Application for a Non-Material Amendment Following a Grant of Planning Permission

Conversion from disused agricultural barn to a single dwelling with external alterations and associated access, car parking and landscaping.
As amplified by Bat Emergence Survey received 16.9.19.

18/01630/FUL

Non-Material Amendment(s) Sought

TITLE
**PROPOSED DWELLING
ELEVATIONS – NORTH EAST
AND SOUTH WEST
APPROVED AND PROPOSED**

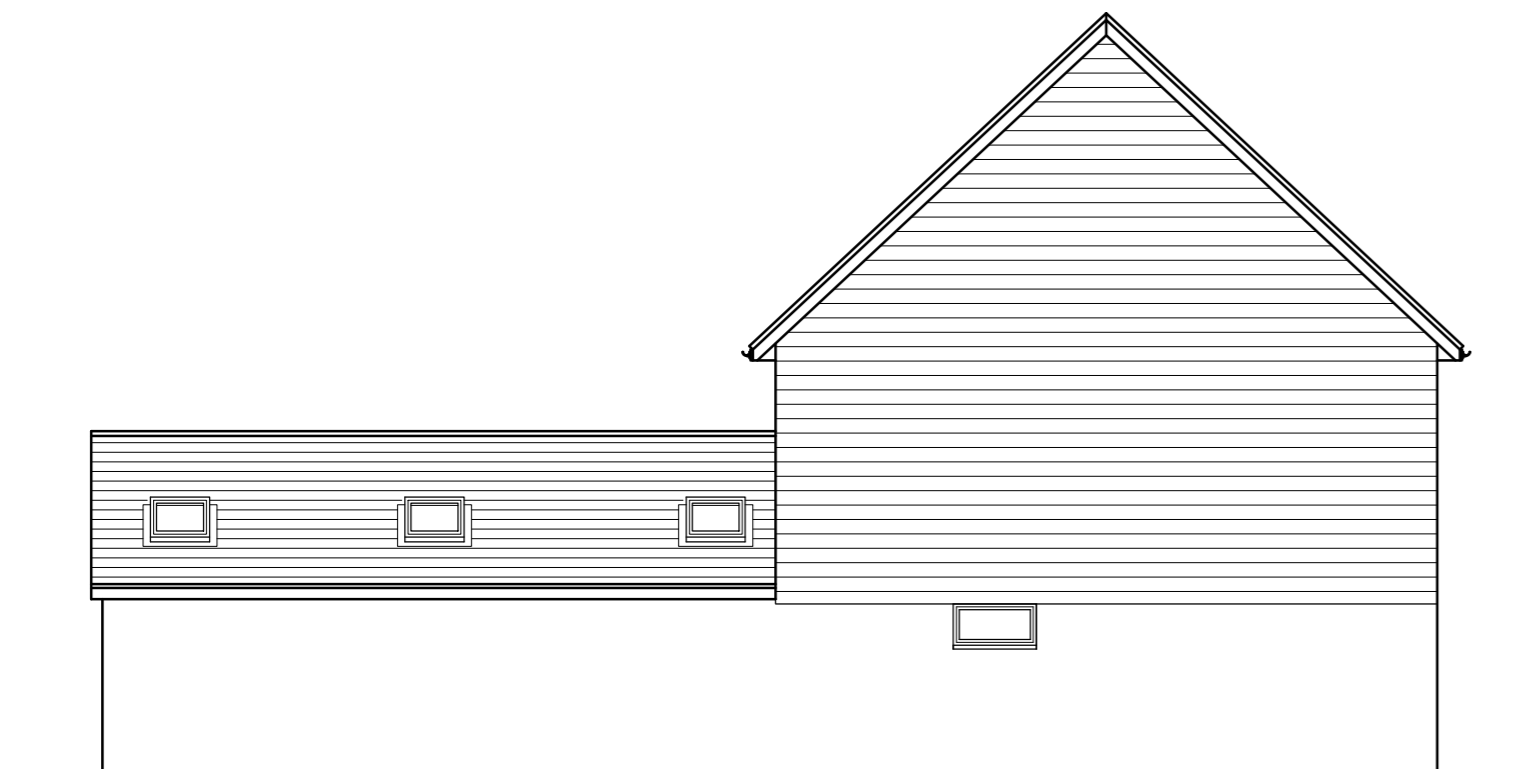
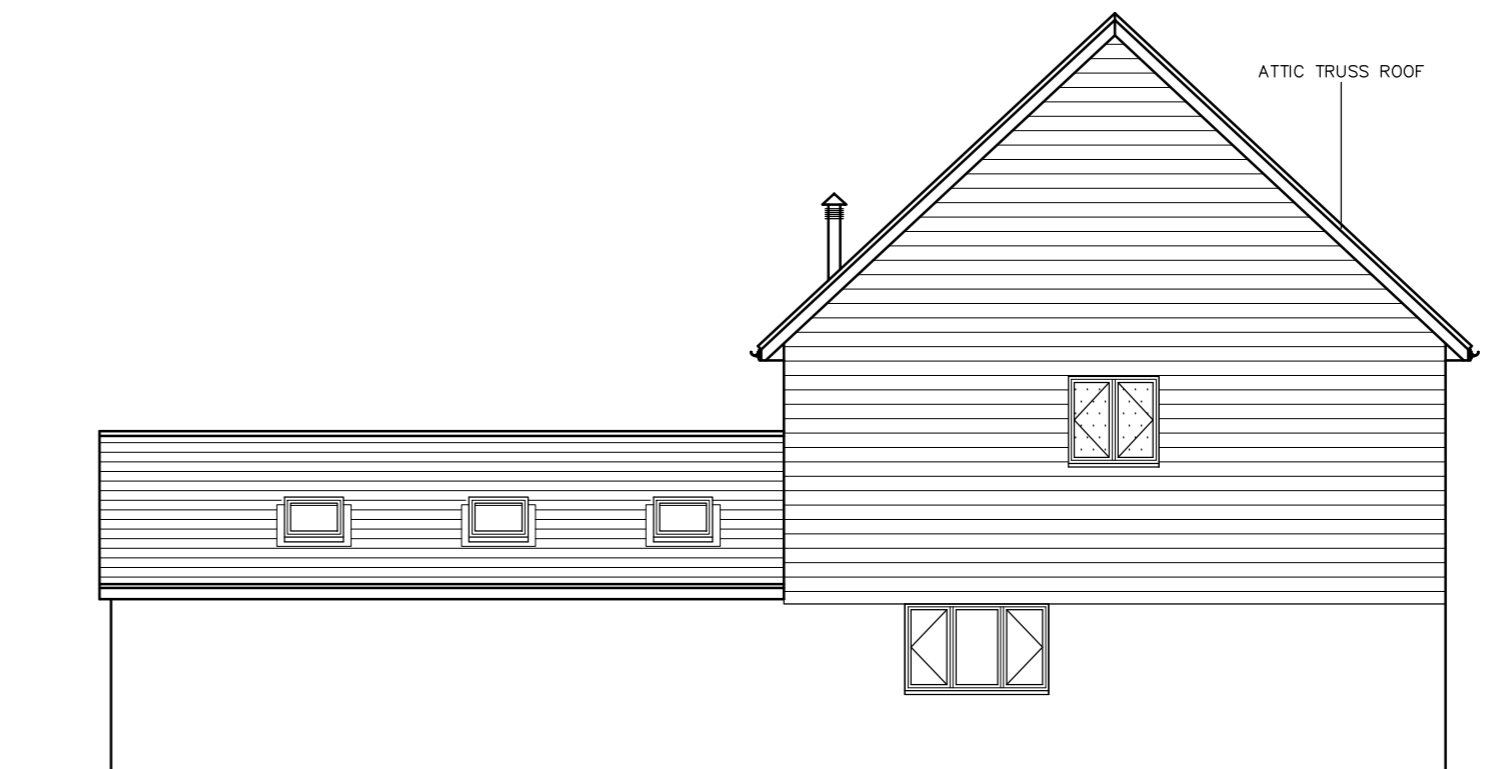
- The applicant is seeking to revise the window designs from the original plans, this is mostly changing 3 panel windows to 2 panel windows, as shown on proposed drawings.
- The applicant is also seeking to introduce 4 no. Roof lights to the roof of the new dwelling to bring in natural light to the home on the North-West Elevation.
- 2 no. Roof lights on the South East elevation have also been moved higher up the pitch of the roof, shown in proposed drawings.
- The 'Approved and Proposed' drawings which are attached to this submission show the previously approved elevations compared with the Newly Proposed Elevations to ease the process of reviewing the elevations.

TITLE
**PROPOSED DWELLING
ELEVATIONS - SOUTH EAST
AND NORTH WEST
APPROVED AND PROPOSED**

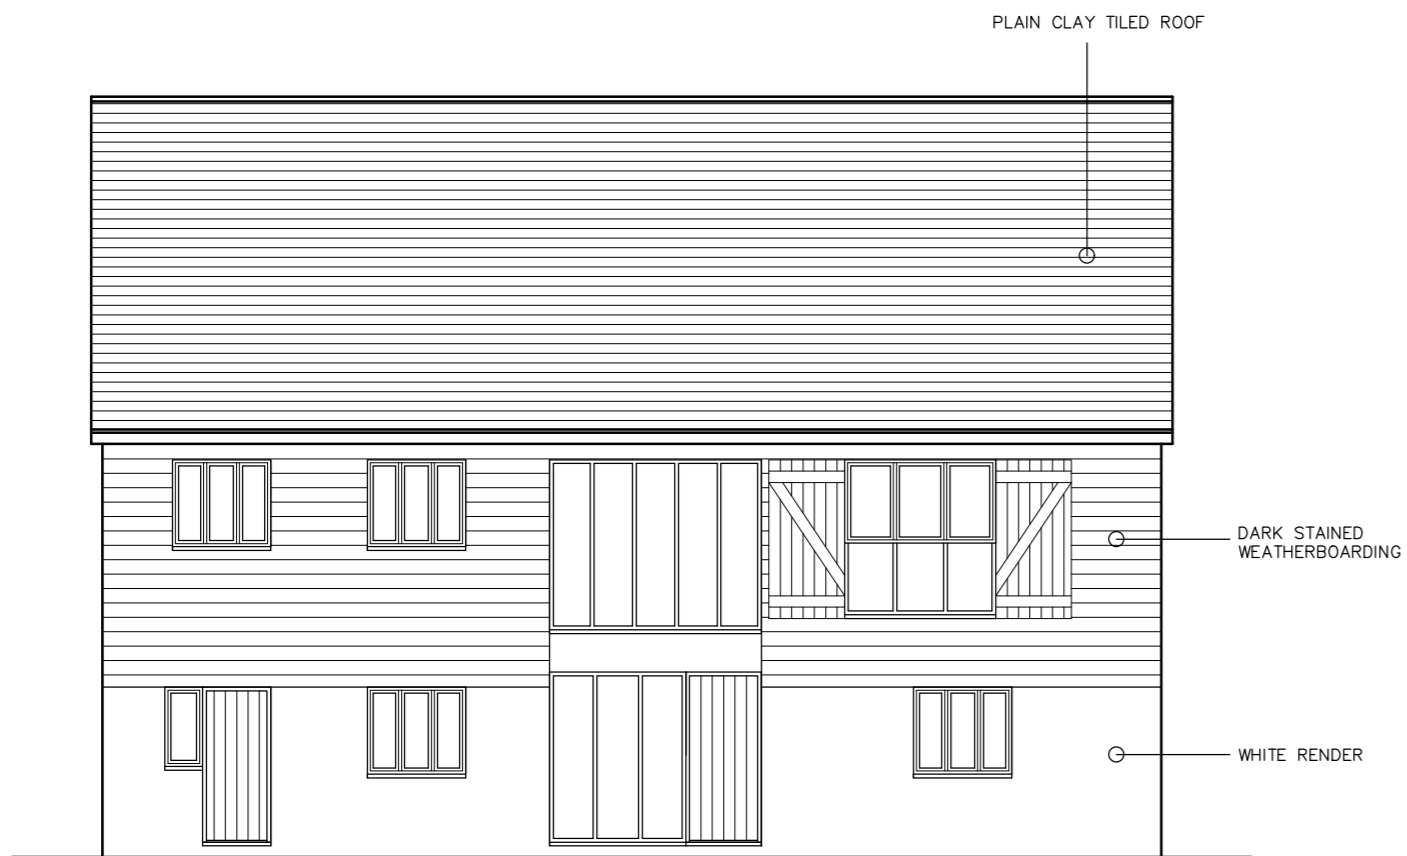
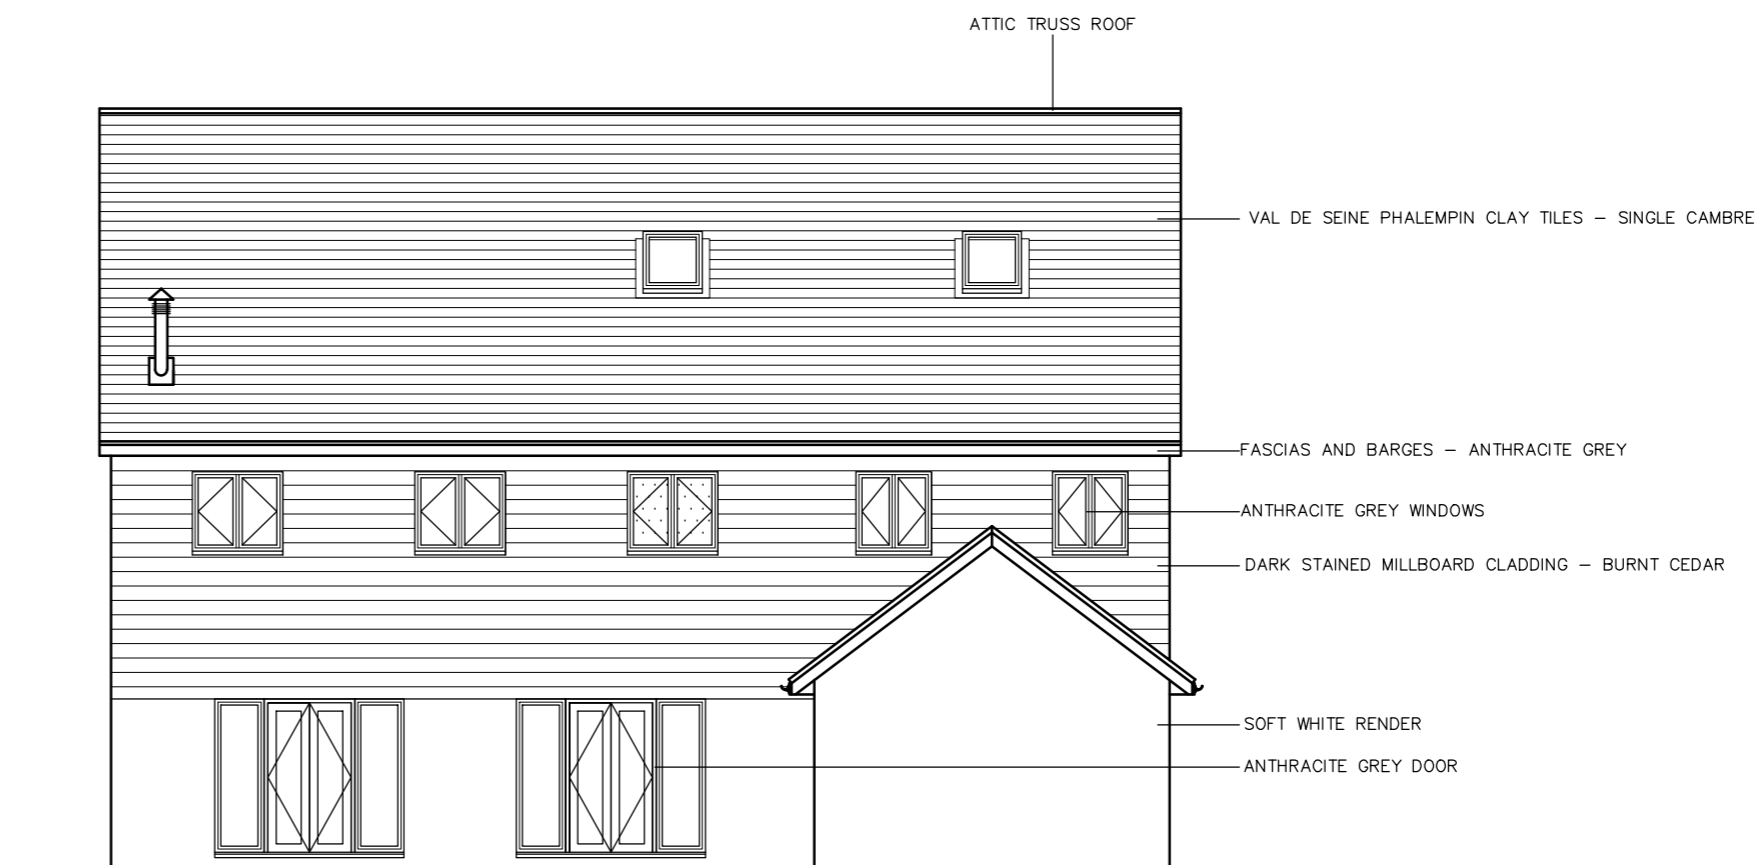
- The 4 no. Roof lights added to the North West Elevation have been added to introduce more natural light to the home, making the entrance hallway feel more inviting and to take full advantage of the Ground floor to Vaulted ceiling height, as shown in section AA in the outline section drawing.
- The window designs have been changed to have a simpler and more uniform aesthetic. The elevations have been revised to promote symmetry in the added glazed units whilst not distracting from the carefully selected external materials which pay respect to the Existing Barns' character.
